# Rezoning Transportation Analysis

Petition Number: #2022-066

Date	Description
09-28-2022	First Review (AO)

TECHNICAL DATA SHEET
FOR
PETITION # 2022-066
ALBEMARLE ROAD APARTMENTS
CHARLOTTE, NORTH CAROLINA

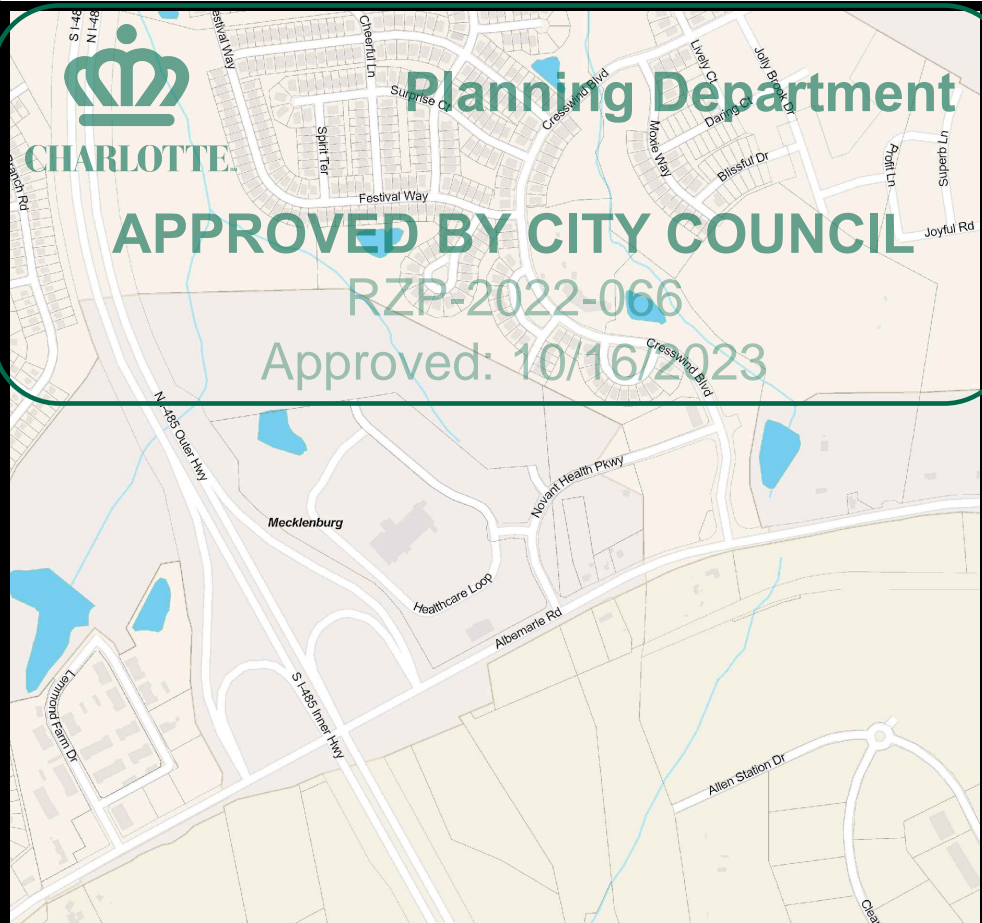
1. **Curbline:** The proposed zoning district has a setback measured from back of the existing or proposed future curbline.
  - a. **Novant Health Parkway:** Maintain existing curbline location.
  - Albemarle Road:** Future curbline location: 44 feet from centerline of Albemarle Road.

Label and dimension the curb and gutter from the centerline for each road on the site plan.

3. Revise site plan and conditional note(s) to commit to dedicate 100 feet of right-of-way or existing right-of-way, whichever is greater from the road centerline of Albemarle Road. The site plan shall label and dimension the right-of-way from the road centerline of Albermarle Road and Novant Health Parkway.
4. Revise site plan to remove 35x35 sight triangle from the intersection of Albemarle Road at Novant Health Parkway. See advisory information regarding sight triangles.

5. Revise site plan and conditional note(s) to commit to maintaining existing bike lane along Novant Health Parkway.
6. A site plan note(s) specifying dedication and fee simple conveyance of all rights-of-way to the City before the site's first building certificate of occupancy is issued as needed. CDOT requests rights-of-way set at 2' behind back of sidewalk where feasible.

9. Revise site plan to construct a 12-foot /multi-use path on Albemarle Road. The site plan shall label and dimension both items from the back of curb and gutter. The entire facility must be outside of the right of way and within a public access easement. Add conditional note committing to construction and maintenance of the 12-foot multi-use path on Albemarle Road.
